Strata Plan 19388

23 February 2013

Mixed Use Development at 23-37 Lindfield Ave, Lindfield MP08_0244 MOD 1

Drawing Title
BASEMENT 3 PLAN

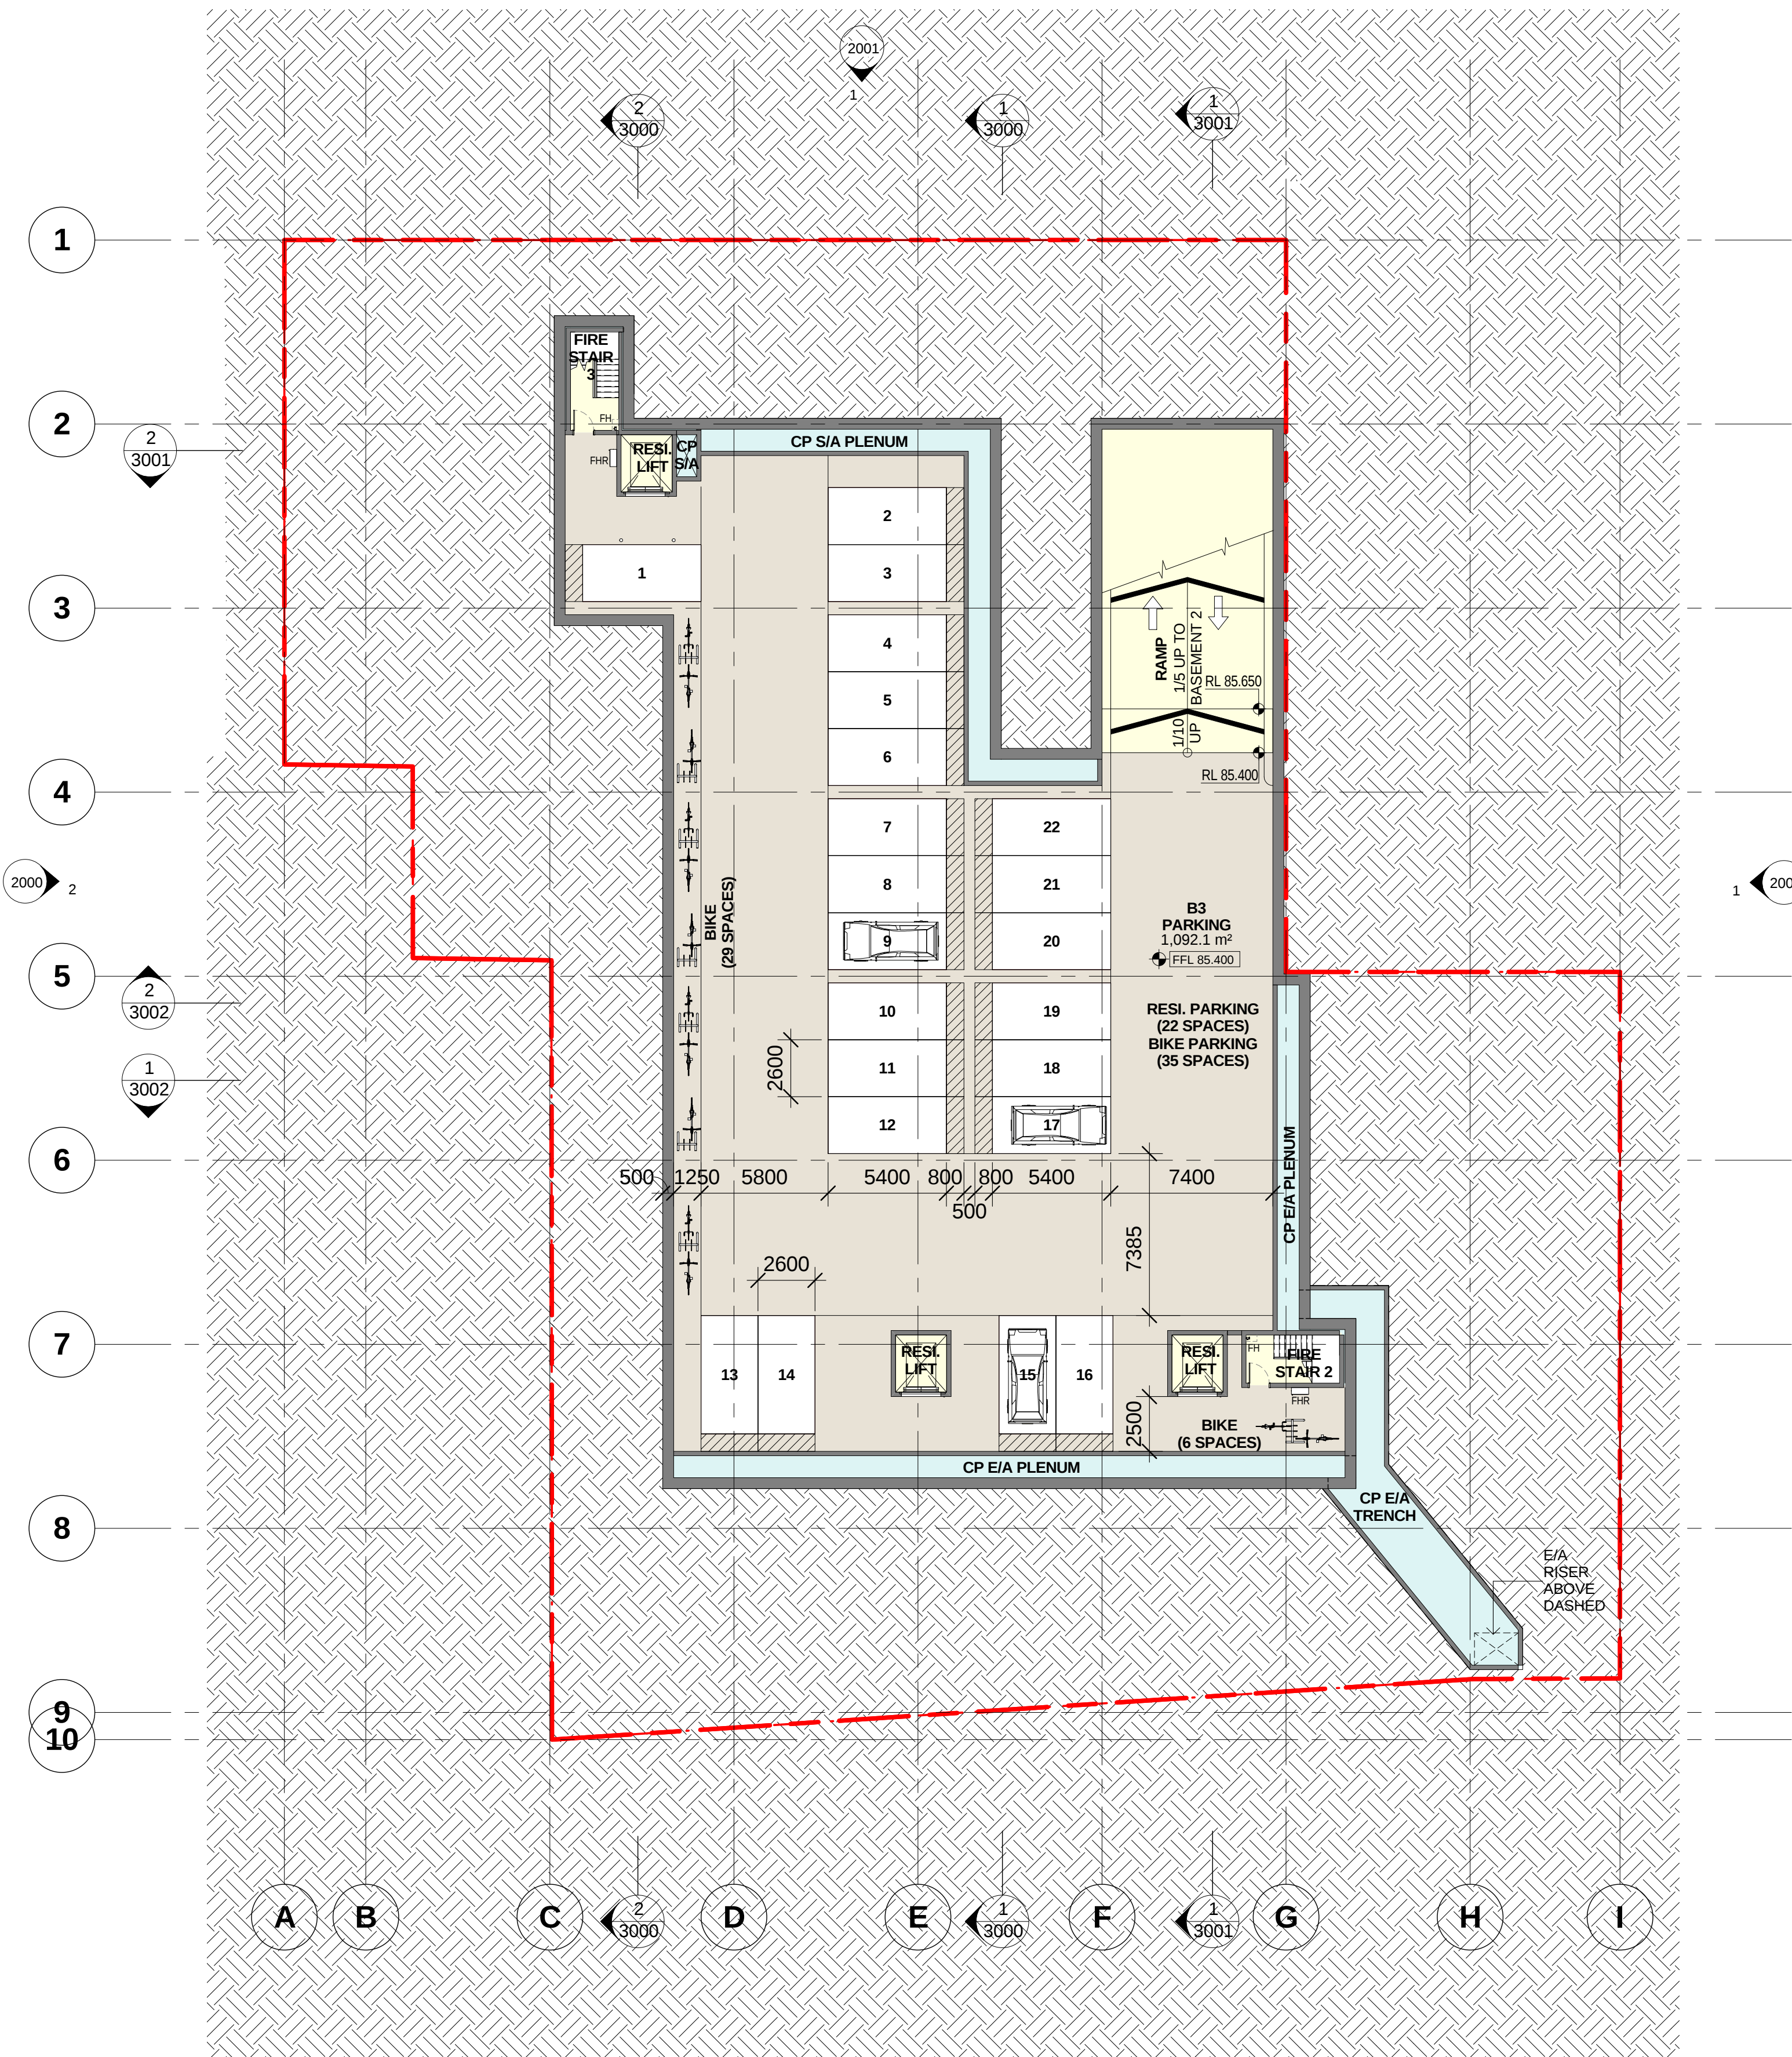
It is noted that the proposed development includes substantial excavation of the site adjacent to 2 Kochia Lane. In particular the excavation of the basement car parks to a considerable depth directly adjacent to our building potentially jeopardises the structural integrity of 2 Kochia Lane. Whilst it is acknowledged that, for the development to be viable, a basement car park will be necessary, we object to the plans that would see significant excavation so close to our property.

1 KOCHIA LA ELEVATION
SCALE 1 : 250

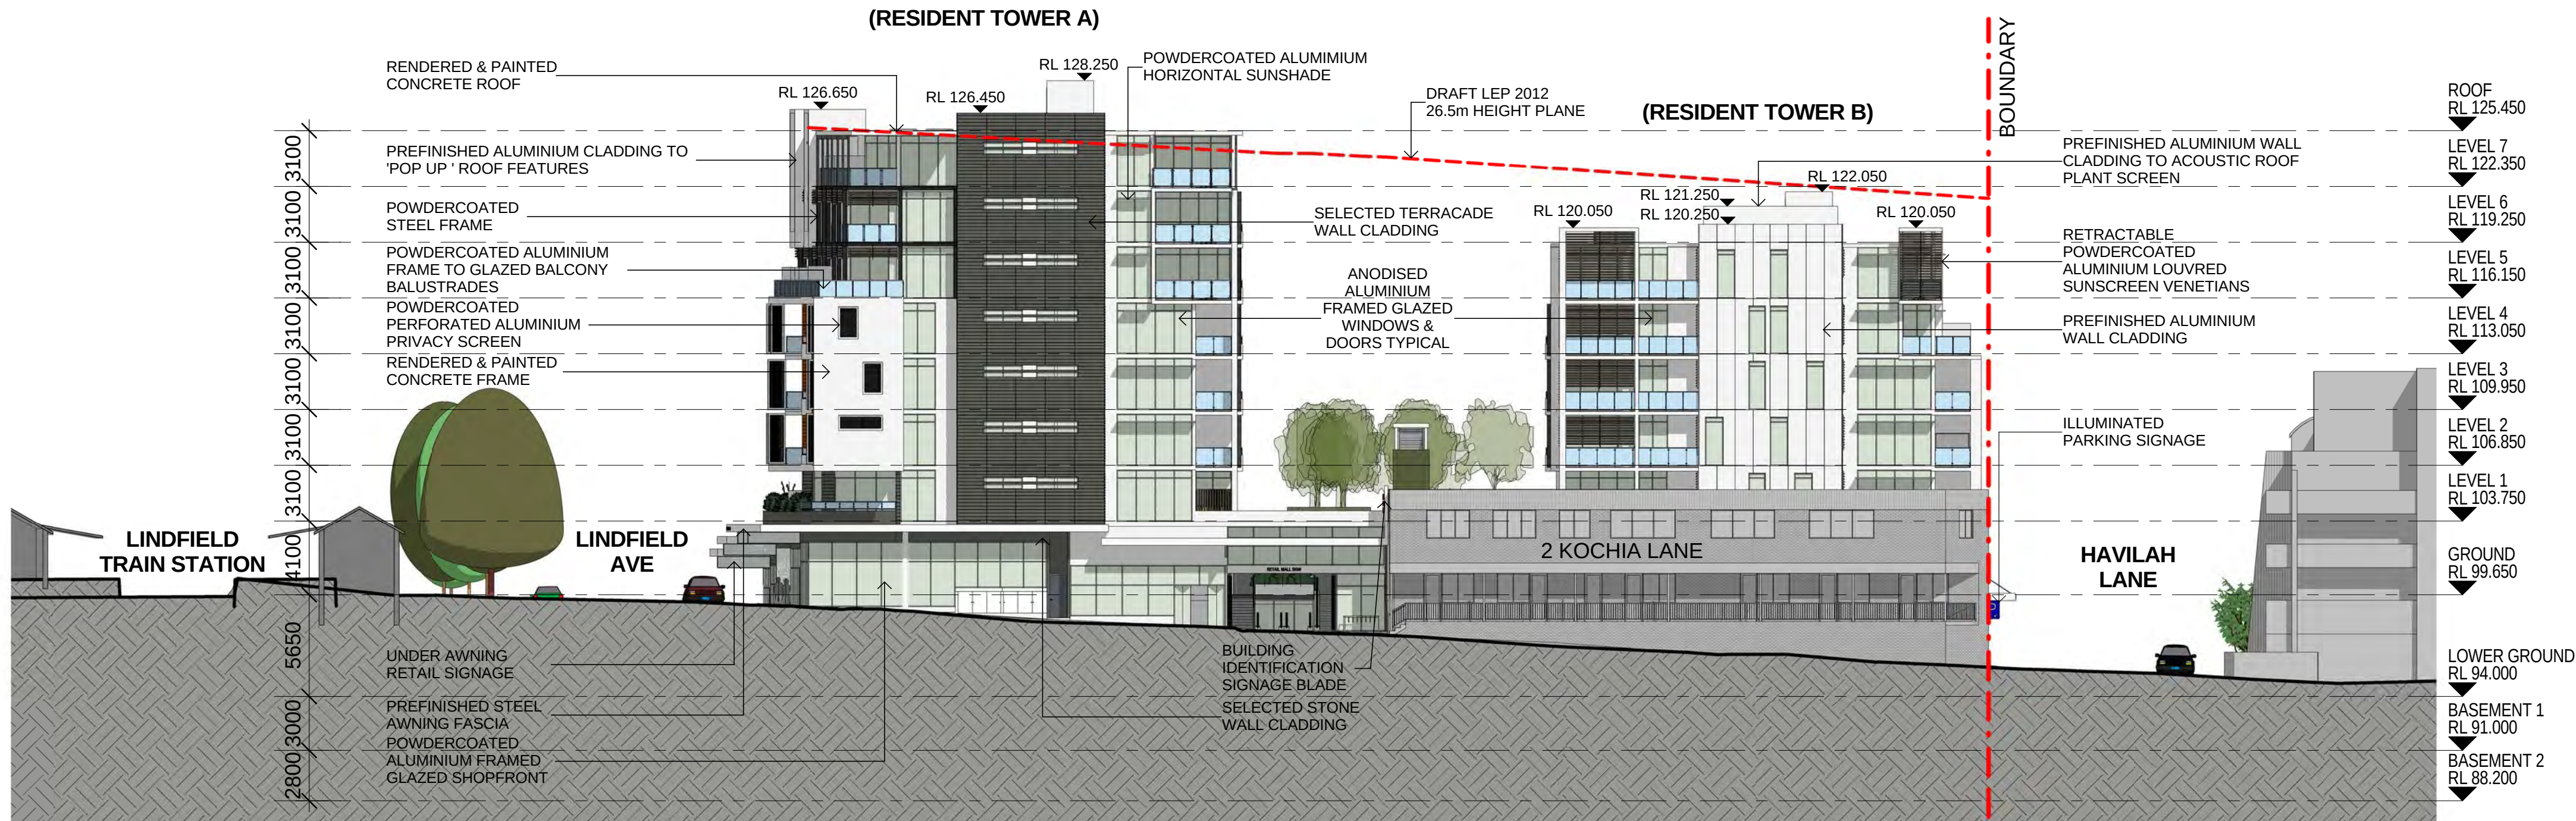
1. The Modified plans have windows and balconies of residential units overlooking our property
2. Any future development of our property would be precluded as the residents on that side of the building would be effected by out increased height
3. An application for development on our site would be restricted by the planned set-back of Kochia Lane.

square would be severely compromised by 2 Kochia Lane (a particularly unattractive and old building) dominating one side of the square. Indeed the design of the proposed development would see a singular blank wall rising 3-4 storeys above 2 Kochia Lane further detracting from any aesthetic appeal. The overall affect of which is the lessening of the value of the surrounding buildings and a significant detraction from the overall 'feel' of the town centre.
